RE: University Credit Union, 1071 Brighton Avenue, Portland, ME

CBL: 274 -D-016 Application # 2006-0221

**VICINITY OF 1071 BRIGHTON AVENUE  
CONDITIONAL USE AND SITE PLAN REVIEW**

Shukria Wiar, Planner  
Barbara Barhydt,  
Development Review Services Manager  
March 22, 2007

1 WEST ELEVATION — TAFT AVE.  
 A2.2a 1/8"=1'-0"

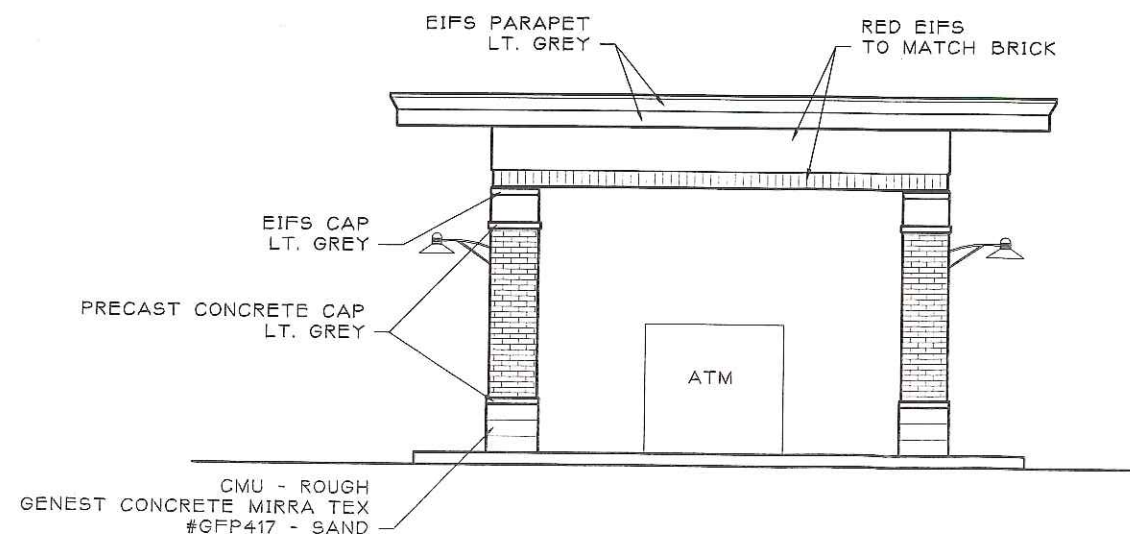
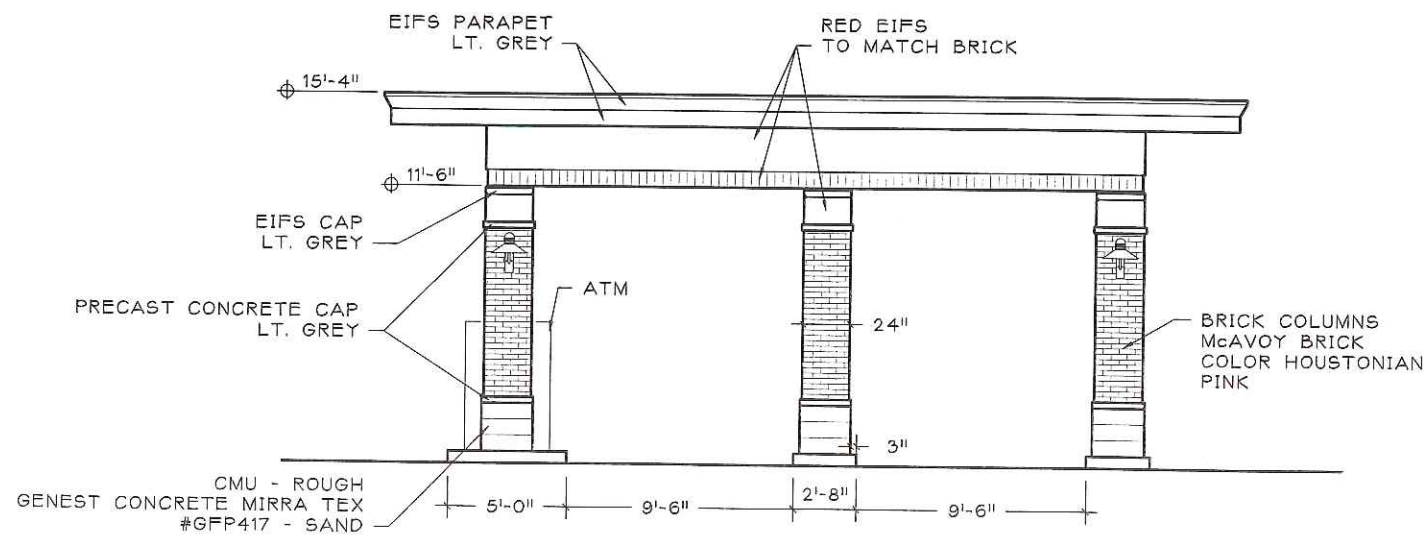
The proposed University Credit Union building is a one-story structure with a cornice detail along the flat roof. Large storefront windows are proposed across the South Elevation on the front façade along Brighton Avenue. At the corner of the building, near Brighton Avenue and the side parking lot, a rotunda area is proposed with large windows. The East Elevation along the side parking lot includes an entrance to the building. The North Elevation along the back parking lot includes a building entrance near Taft Avenue. The West Elevation along Taft Avenue includes large storefront windows.

EXTERIOR SIGN KEY

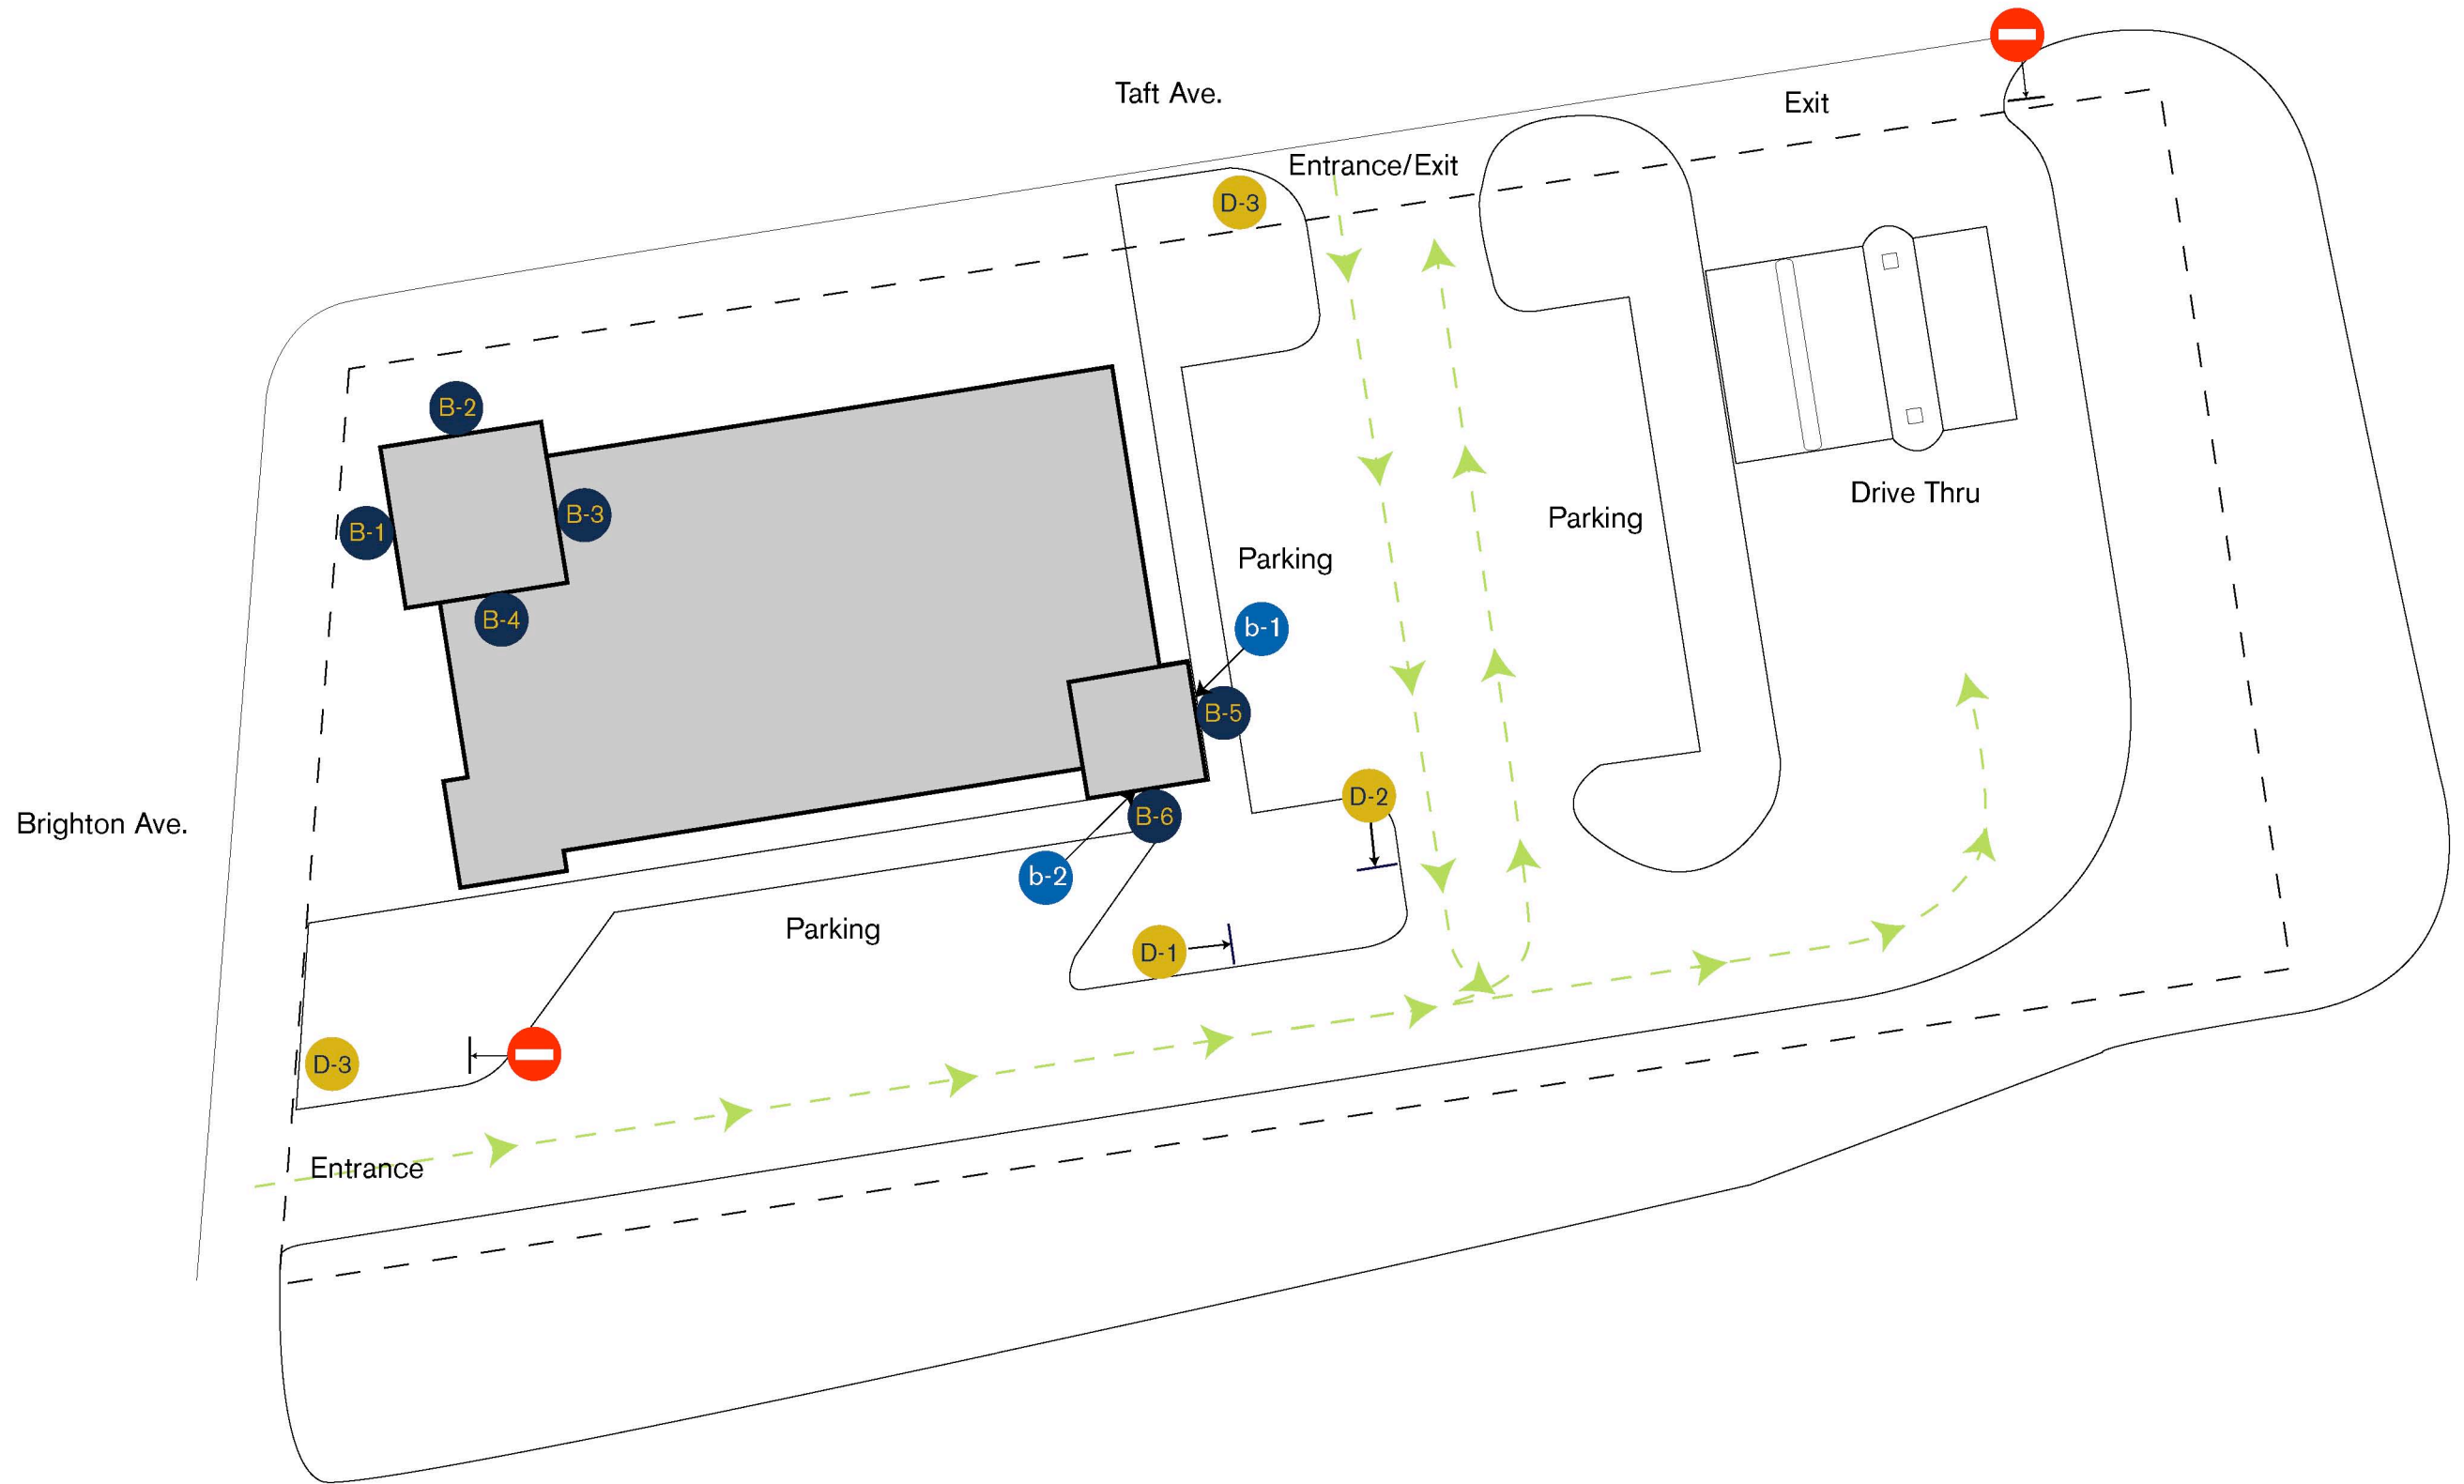
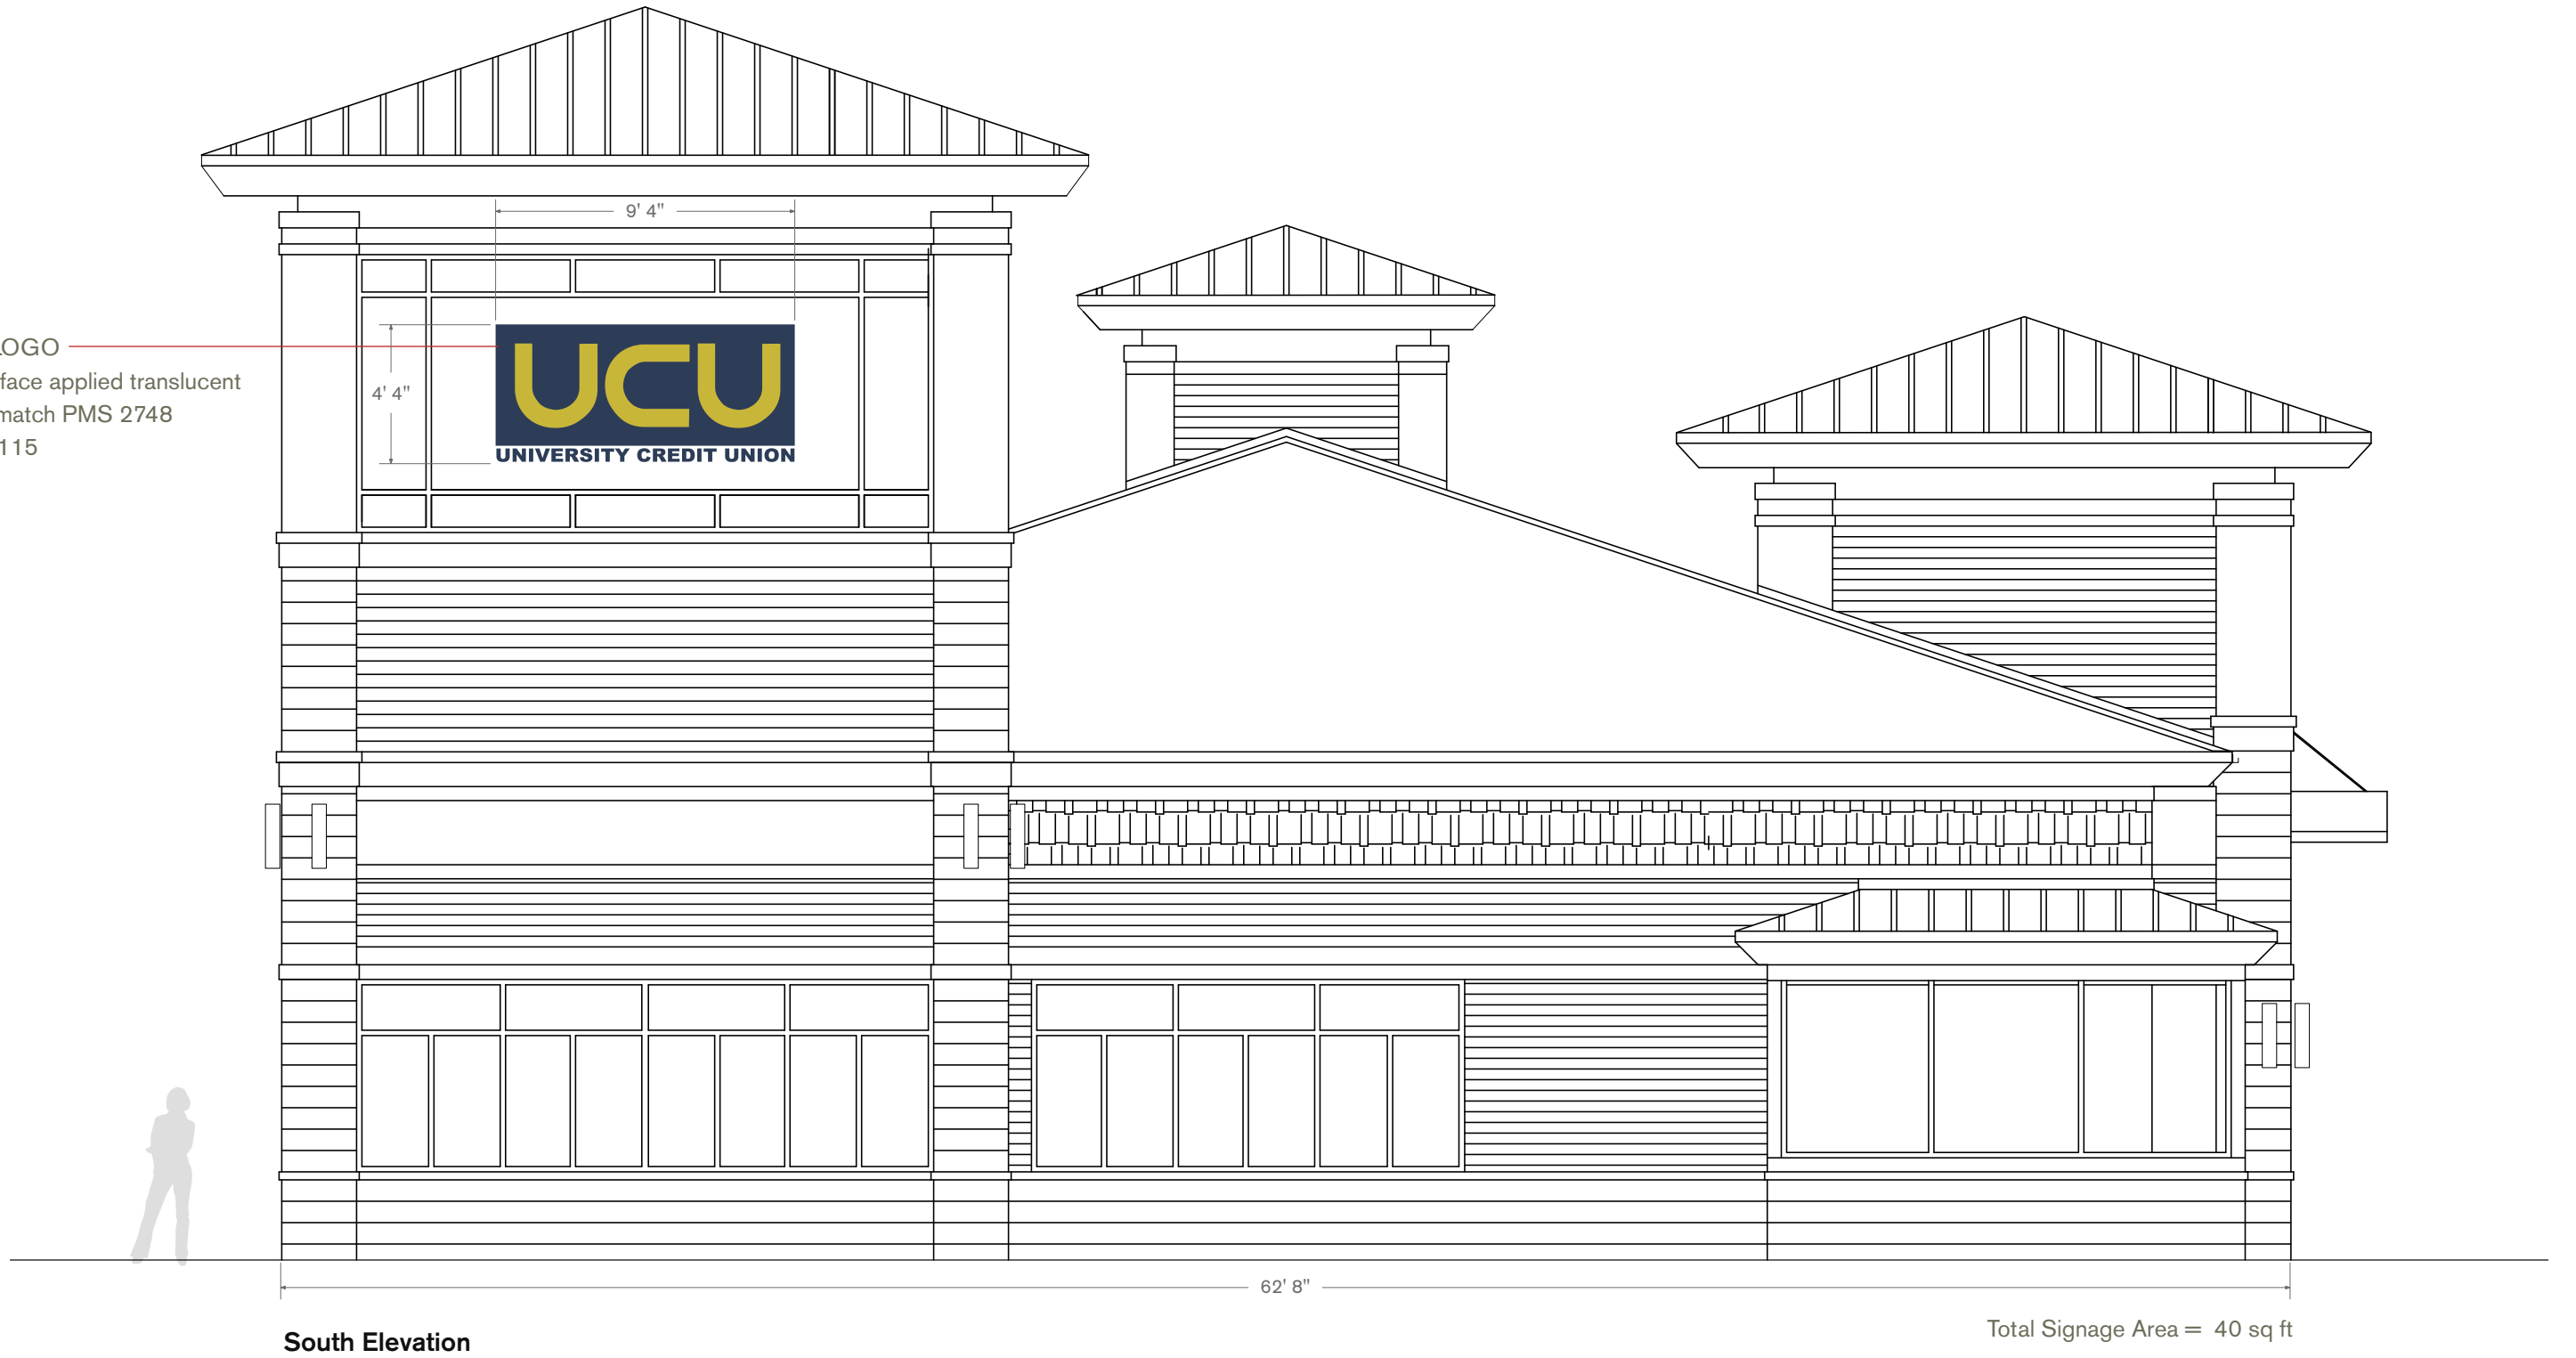
The signage plan is included as Attachment #21. Three-dimensional back-lit letters are proposed for the rotunda. The blue letters are 1' 5" high and 4" wide, which create a signage band above the rotunda's storefront windows measuring 28 square feet. The initials, UCU, are shown as three-dimensional back lit letters in gold on the East Elevation (facing side parking lot) and the West Elevation (facing Taft Avenue). Each of these signs is 9 square feet in total area. An entrance sign is proposed along Taft Avenue using the proposed building materials to create a planter base and an internally illuminated sign is proposed that has a total area of 27 square feet per side.

Three directional signs are shown on the site and all of the signs are located on the applicant's property. The directional signs are shown in Attachment #21. The sign panels are blue with white lettering and a gold ban. The posts and arch are silver and the base panels are a light gray.

The proposed signs do not adversely affect visibility at intersections or access drives and the signs advertise only the services offered on the premises. Refer to the Site Plan Review (Section VII, subsection 12) for further discussion of the proposed signs for the project.

- i. The infrastructure contribution of \$22,700 for the Brighton Avenue Street improvements shall be submitted prior to the issuance of a building permit.
- ii. The proposed sign dated March 12, 2007 meet the B-2 zone and the site plan standard for signs, Sec. 14-525 (22); however, separate sign permits must be obtained from the Inspections Division prior to installation.
- iii. The applicant shall submit sewer and water capacity letters prior to the issuance of a building permit.
- iv. The lighting fixtures shall be reviewed and approved by the City's Urban Designer prior to issuance of a building permit.
- v. The applicant shall work with Carrie Marsh, Urban Designer on the use of EIFS on the exterior of the building, particularly at the pedestrian level, prior to the issuance of a building permit.
